**WEST SUSSEX COUNTY COUNCIL
PLANNING SERVICES CONSULTATION**

SUBJECT: FP/219/17/HH - Vehicular access.

88, Flansham Lane, Felpham, Bognor Regis, West Sussex, PO22 6AH

17/4483/1

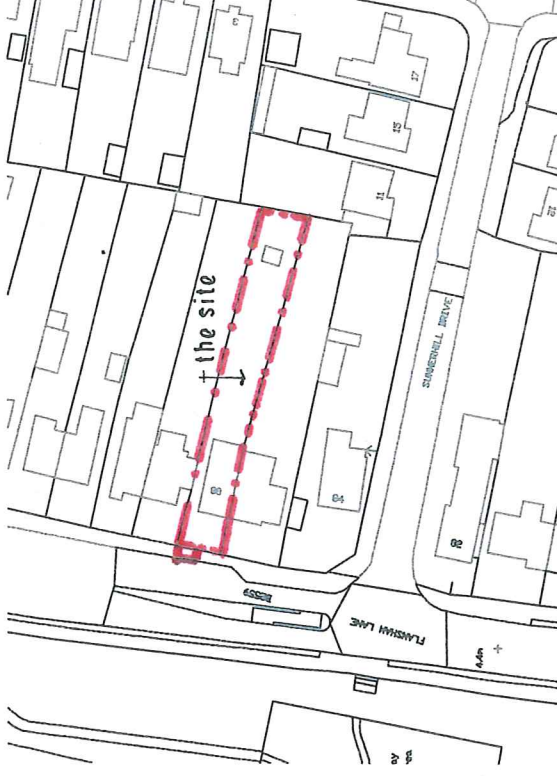
The proposal is for vehicle crossover (VCO) of approx. 3.4 m width at the above site to facilitate access to a single off-street car parking space for the existing dwelling. From an inspection of the plans and local mapping there is sufficient space indicated on the frontage to accommodate this.

Flansham Lane is 'B' classified and subject to a 30mph speed restriction in this location. A turn on site would be preferred, clearly though there is insufficient space to achieve this. However other properties have similar arrangements that have been operating without evidence of highway safety concern.

A license to construct the vehicular cross over would need to be obtained from the Arun Area Engineer. It should be noted that a licence at this location is unlikely to be granted; this area is subject to a policy that a licence would not be granted for an access through layby due to the existing parking pressures and the loss of on-street parking provision for neighbouring residents. It is recommended that the LPA consider the amenity impact of the proposed development should permission be granted.

Nevertheless the Local Highway Authority would not raise a highway safety concern or transport grounds to resist the proposals.
